**FIVE ESTUARIES OFFSHORE
WIND FARM**

**SCHEDULE OF CHANGES TO THE DRAFT
DEVELOPMENT CONSENT ORDER
(TO REVISION C, CHANGE REQUEST)**

Application Reference	N/A
Application Document Number	N/A
Revision	N/A
APFP Regulation:	N/A
Date	October 2024

DRAWING NUMBER: 005105342-01
 APPF Regulation: 5(2)(a)
 Sheet No: 1 of 3

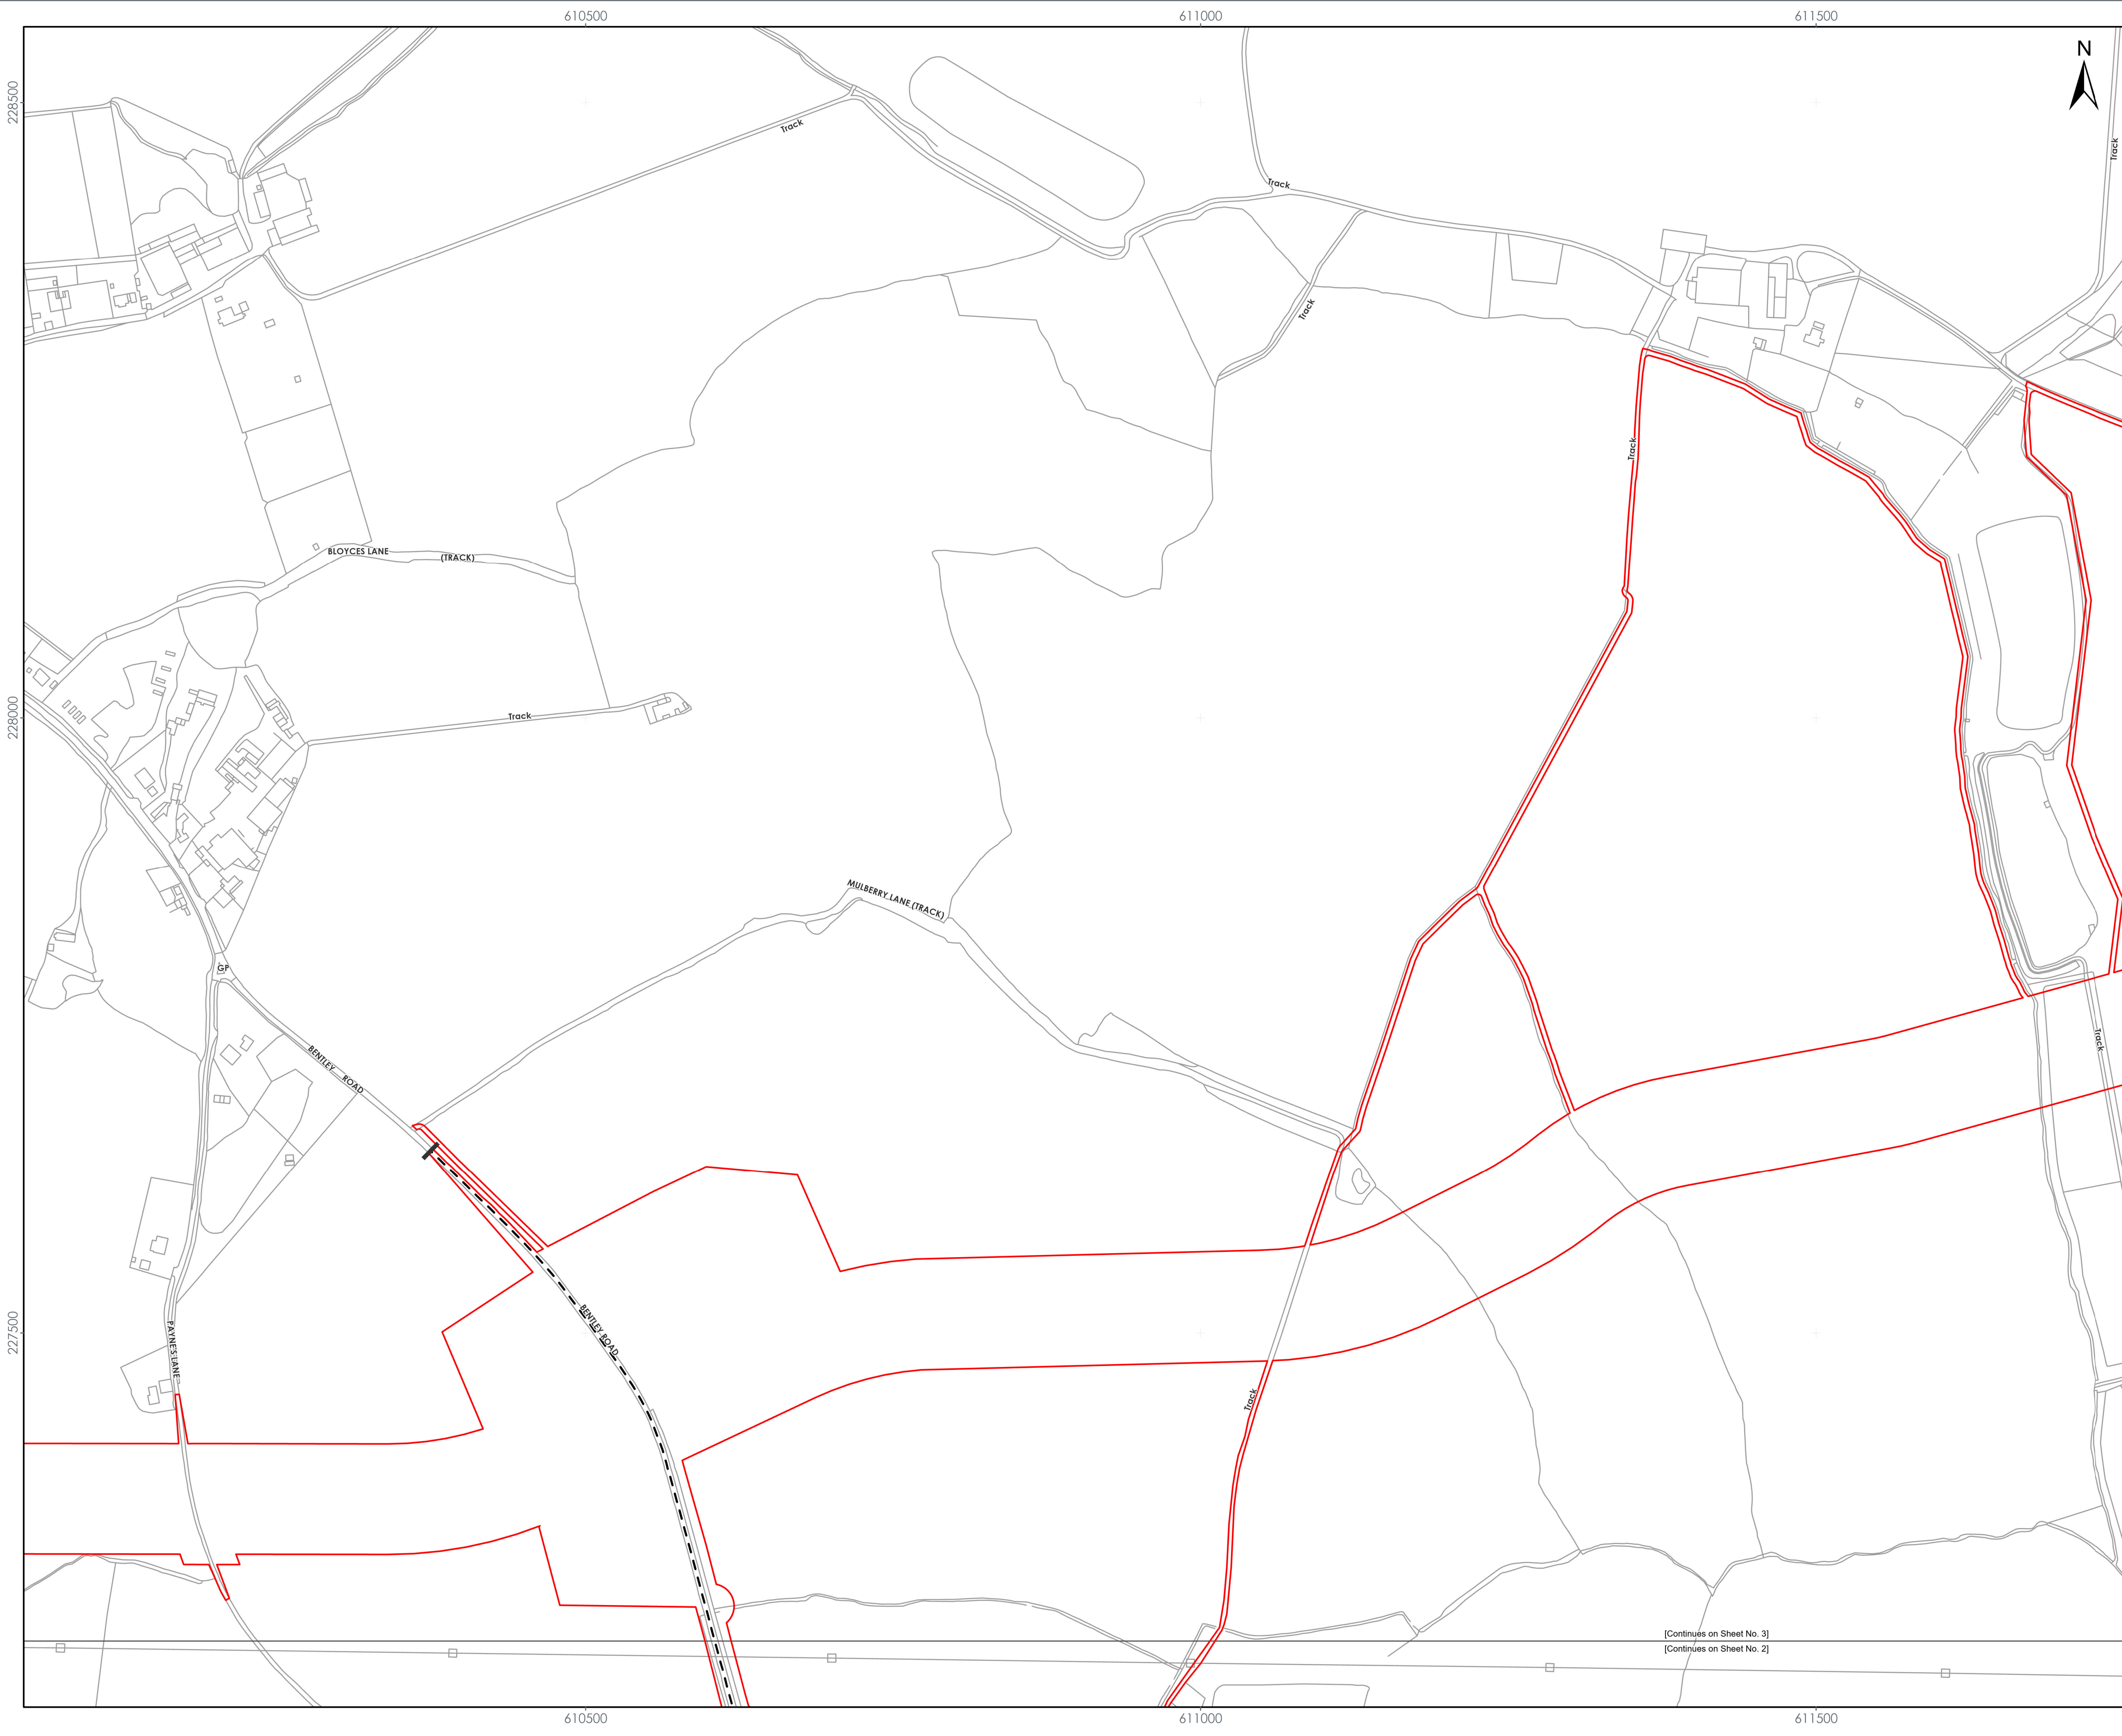
<i>(1) Area</i>	<i>(2) Road name, number and length</i>	<i>(3) Speed Limit</i>	to correct a typographic error
District of Tendring	B1033 (Thorpe Road / Frinton Road) for a distance of 1.4 kilometres shown with a dashed line on sheet 1 on the Temporary Speed Reduction Plans	40 miles per hour	
District of Tendring	Golden Lane for a distance of 0.9 kilometres shown with a dashed line on sheet 2 of the Temporary Speed Reduction Plans	40 miles per hour	
District of Tendring	B1035 Thorpe Road/Tendring Road/Swan Road for a distance of 0.7 kilometres shown with a dashed line on sheet 1 of the Temporary Speed Reduction Plans	30 miles per hour	
District of Tendring	B1035 (Clacton Road) for a distance of 0.5 kilometres as shown with a dashed line on sheet 4 on the	40 miles per hour
